Case Officer: Andrew Thompson

Recommendation: Approval

Proposal: Discharge of Conditions 11 (Framework Travel Plan), 12 (bus stop) and 13 (private minibus service) of 18/00803/OUT

Luminaire EX5

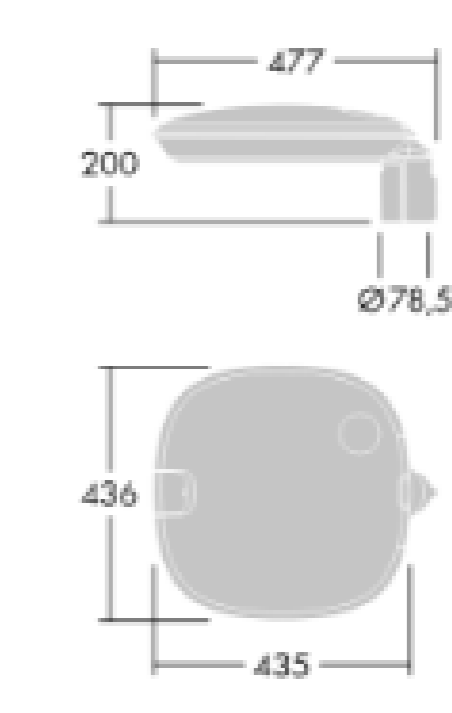
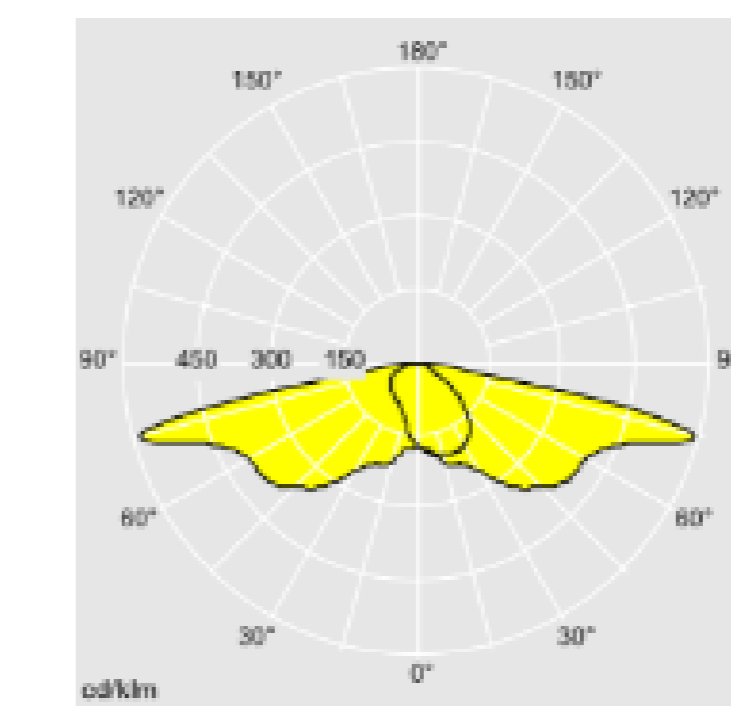
The application is supported by the following plans Proposed Bus Shelter – General Arrangement Plan IMA-22-154 001 Rev D (which supersedes plan ref. IMA-22-154-001-Rev B, previously approved under 23/01437/DISC) appended to the Framework Travel Plan approved under Condition 11 and an additional plan - Bus Stop Lighting - BBSP-HLEA-XX-XX-DR-E-708001-P01 has also been submitted.

Proposed 3 bay Mono bus shelter - Typical arrangement

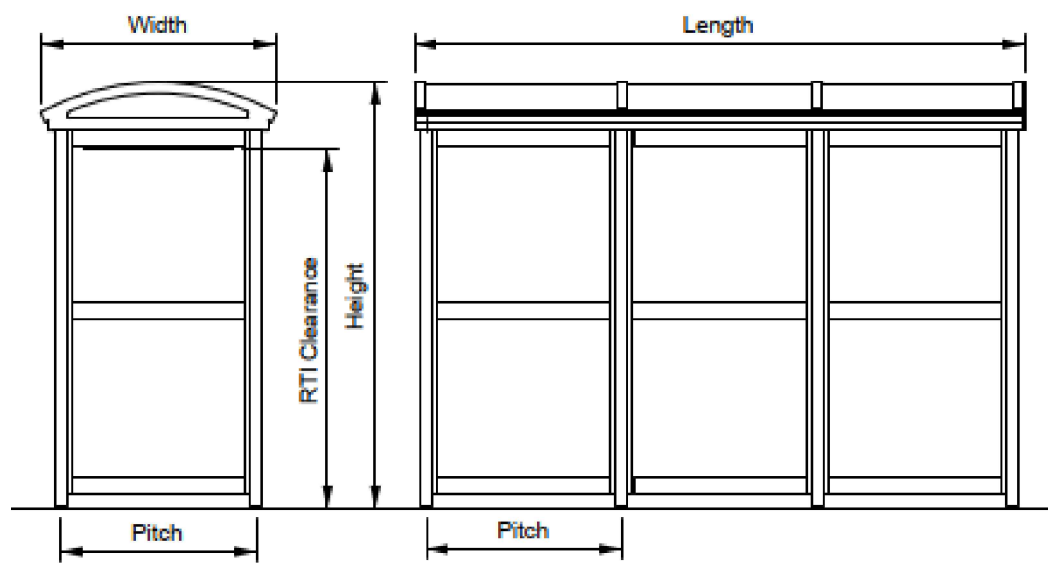
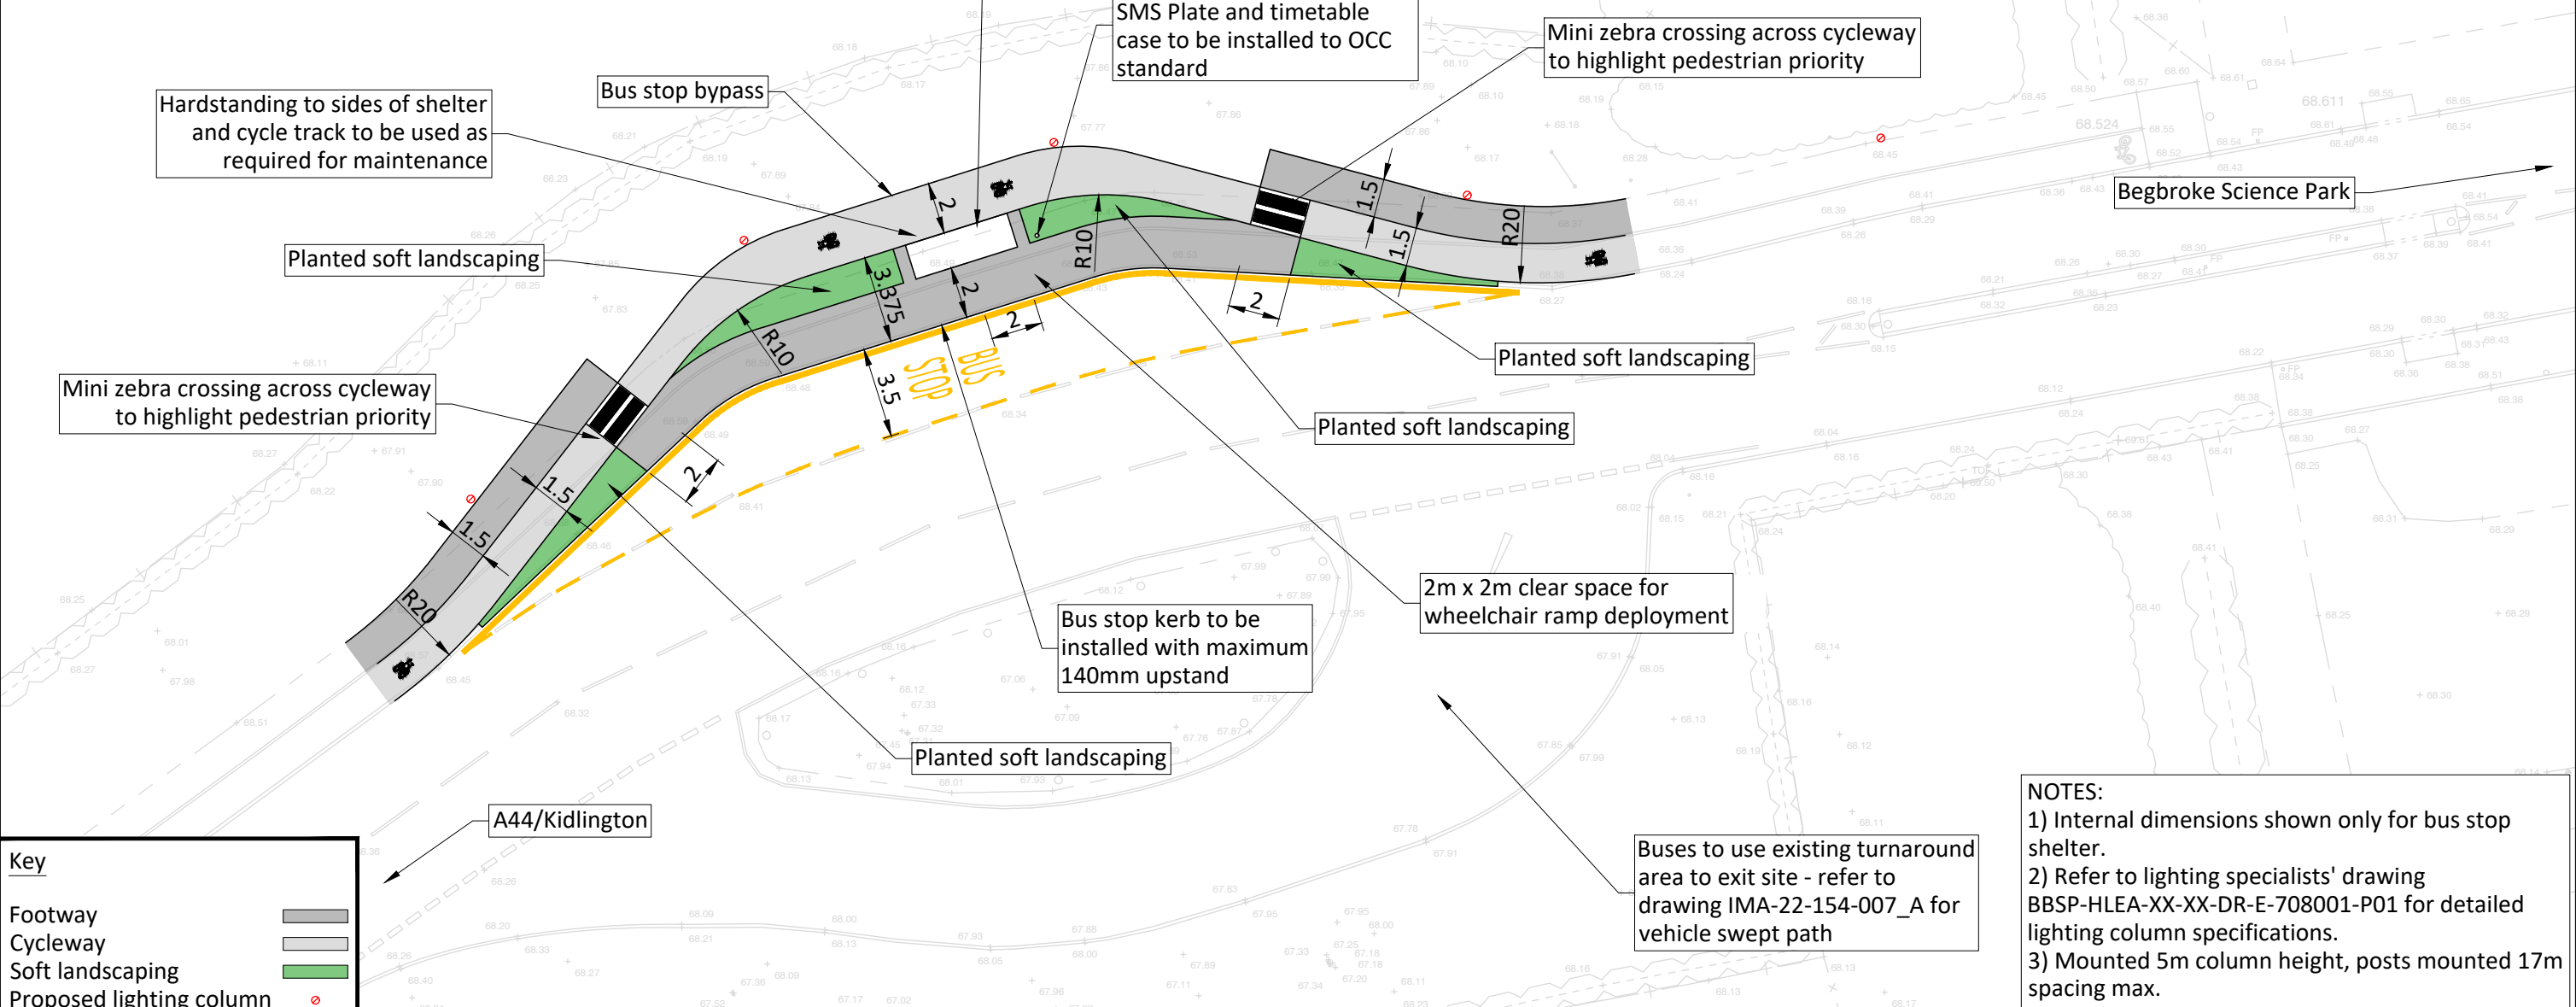
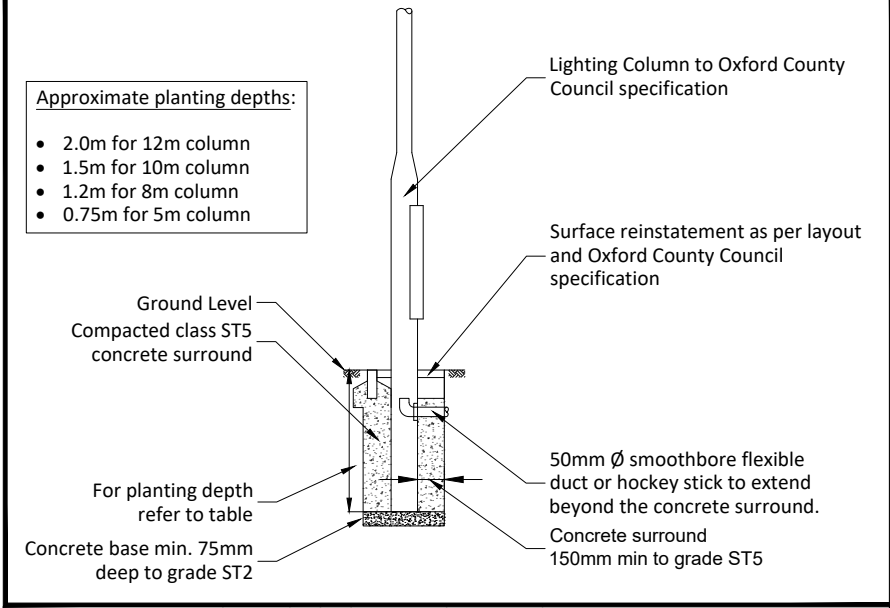
As required by the condition the proposed location of the bus layby is located within existing infrastructure and allows for turning and manoeuvring and includes the provision of a bus stop including a shelter within the site at the existing turnaround area at the eastern end of Begbroke Hill
